Subject: Snowy 2.0 – Main Works Modification 3 (SSI-9687-Mod-3)

I refer to the request for advice from the Biodiversity, Conservation and Science Group (BCS) of the NSW Department of Climate Change, Energy, the Environment, and Water (DCCEEW) regarding Modification 3 (MOD 3) for the Snowy 2.0 project.

Attachment A- BCS Assessment Summary for Snowy 2.0 MOD 3

Figure 3.6: Indicative Marica ventilation shaft and accommodation camp

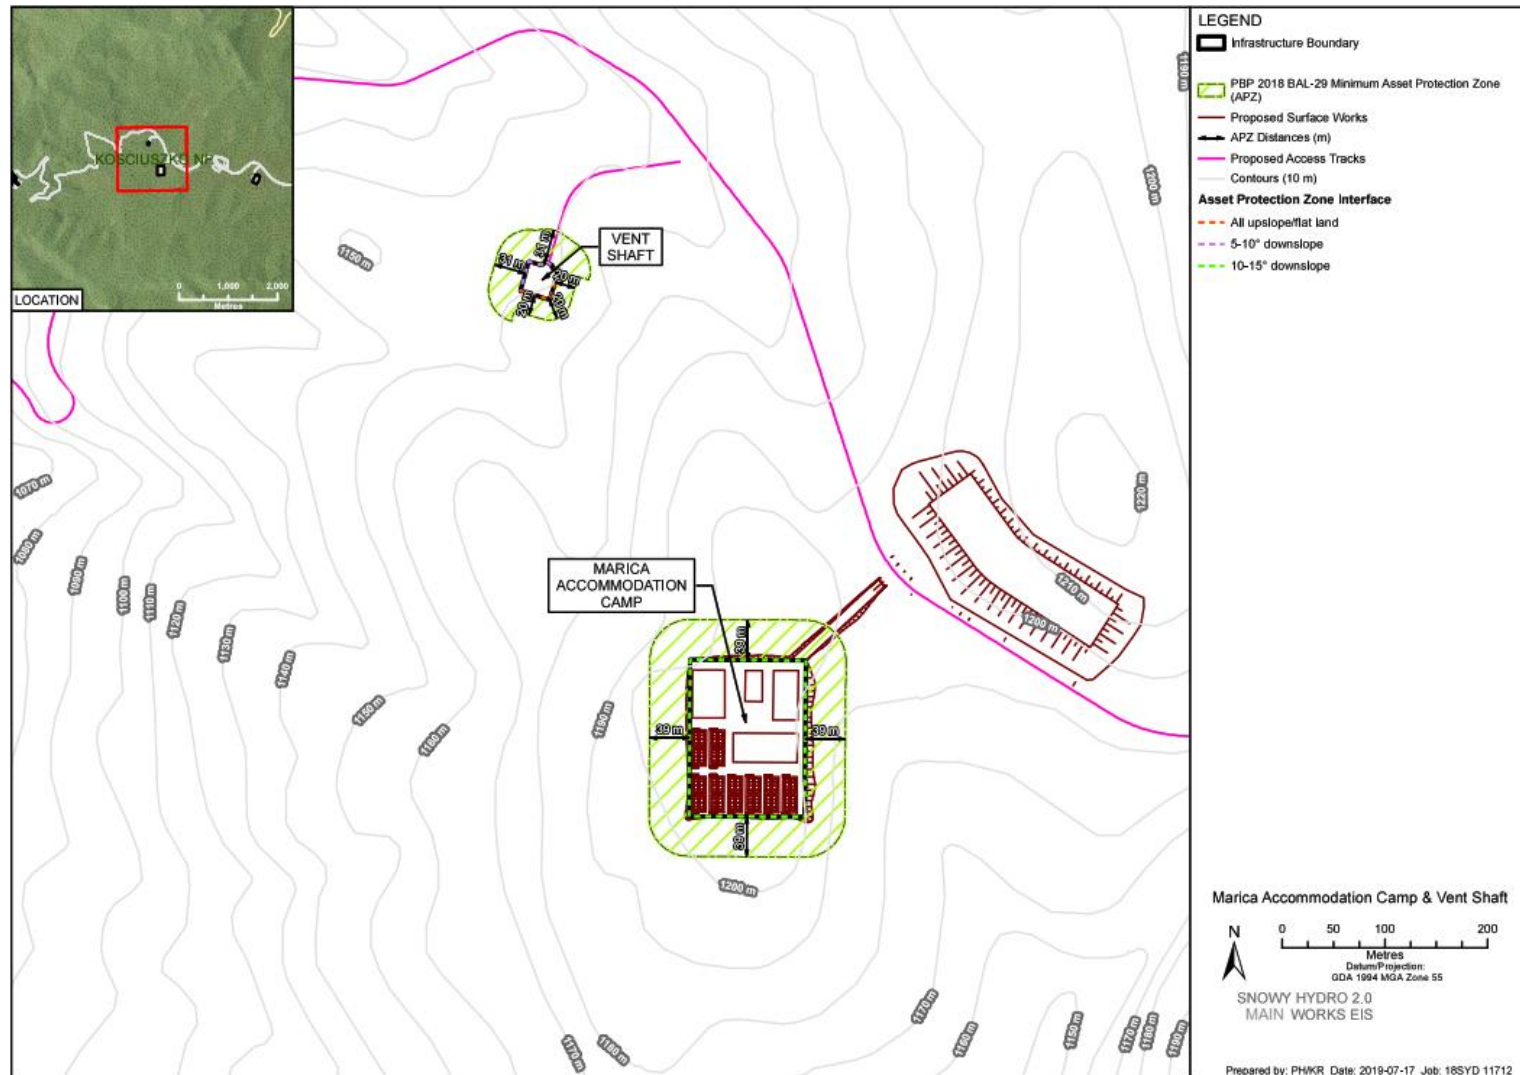
6. **Helipad Location:** The helicopter pad for the Marica camp is to be relocated to a different previously disturbed area to allow for additional accommodation blocks. The location of the updated helipad location has not been provided. BCS seeks clarification of the location to ensure it will occur in low condition vegetation or a previously cleared area to demonstrate the avoid, minimise framework.
